Rezoning Transportation Analysis
Petition Number: Insert Zoning Petition #2021-195
General Location Identifier: 20105108, 20105106

Revision Log:

Date	Description
12-28-2021	First Review (PDM)

The petition is located adjacent to Arrowood Road, a State-maintained major thoroughfare and Interstate 485, a State-maintained freeway. The petition is location within the limits of the Steele Creek Area plan and is located outside Route 4. The petition is a site plan amendment to the previously approved rezoning 2018-121.

RZ-1

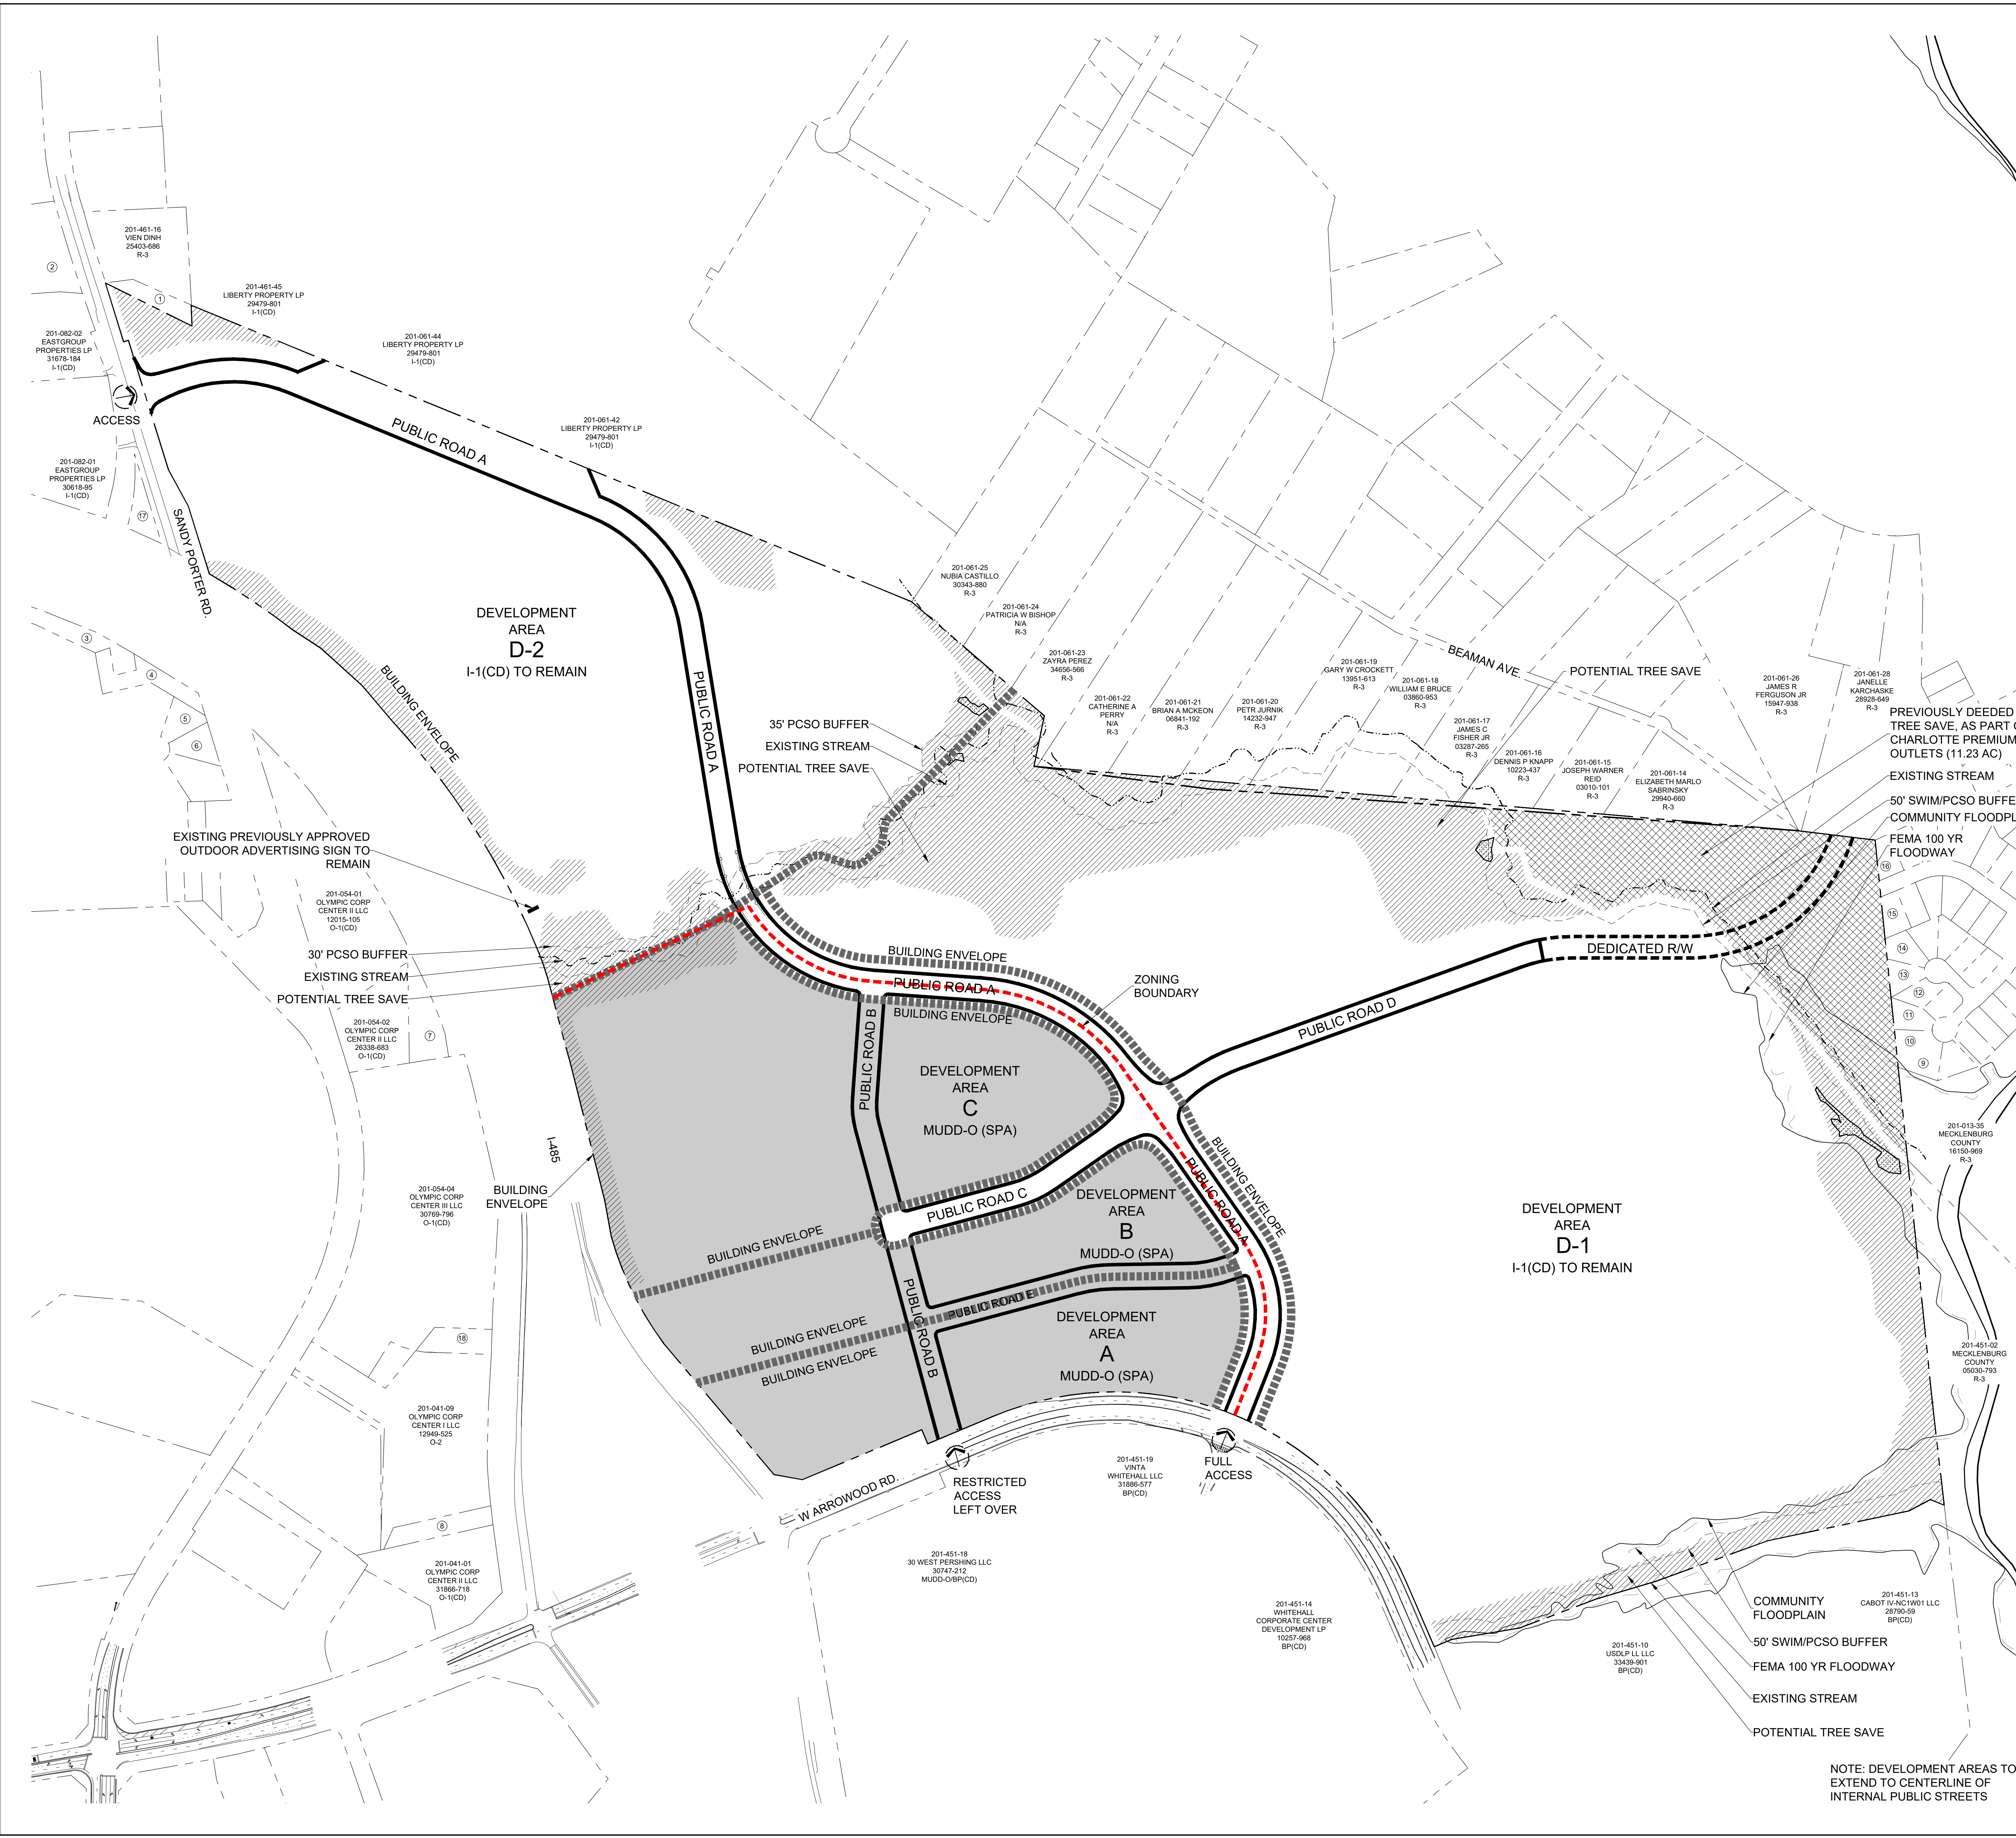
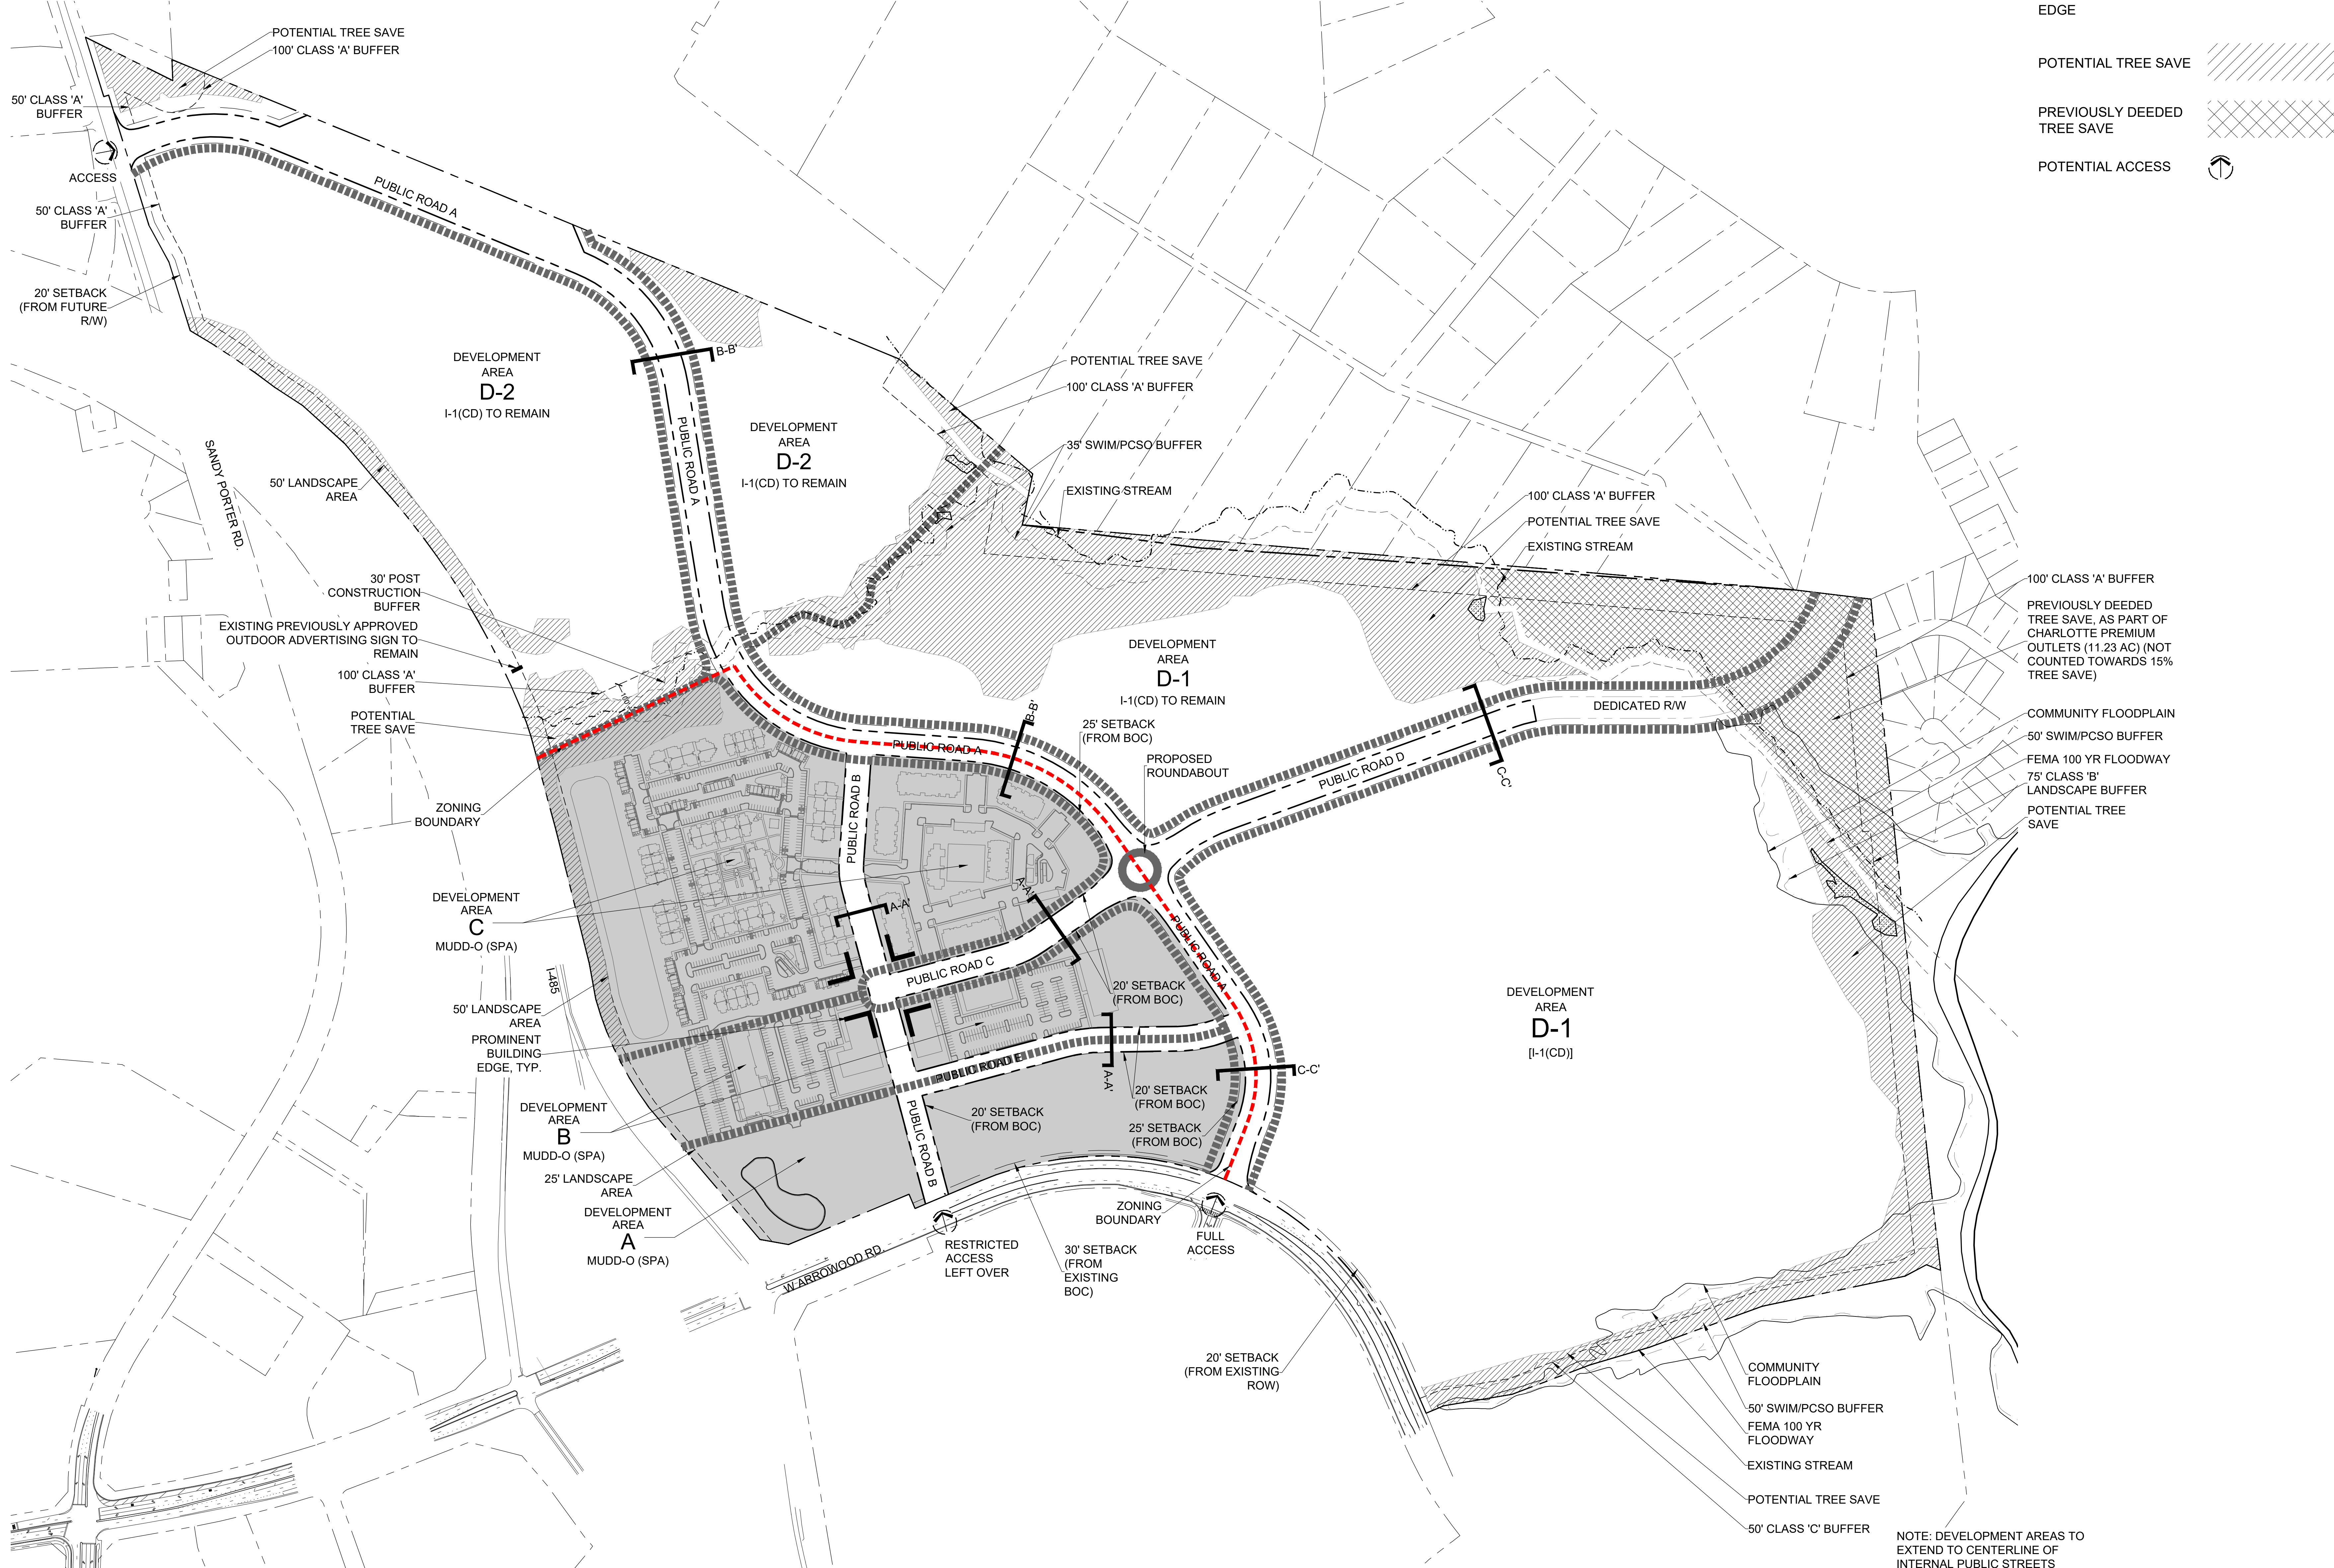
1. **Curblines:** The proposed zoning district has a setback measured from back of the existing or proposed future curblines.
 - a. **Arrowwood Road:** The future location of curb and gutter is in the existing location

Label and dimension the curb and gutter from the centerline for each road on the site plan.

3. Revise site plan and conditional note(s) to commit to construct an 8-foot planting strip, and 12-foot sidewalk on the entire property frontage of Arrowwood Road per Chapter 19 and Chapter 20. The site plan shall label and dimension both items from the back of curb and gutter and road centerline. The 12ft multi-use path also meets the council adopted Charlotte WALKS and Charlotte BIKES policies.

4. Revise site plan and conditional note(s) to commit to constructing an 8-foot planting strip and 12-foot multi-use path along Sandy Porter Road per the pervious approved rezoning. The previous note show below should be used.

5. Revise site plan and conditional note(s) to restrict Public Road E access at Public Road A to right-in / right-out if the required minimum intersection sight distance cannot be achieved.

6. Add conditional committing to the dedication of right-of-way to allow for the extension of Public Road D to the property line.
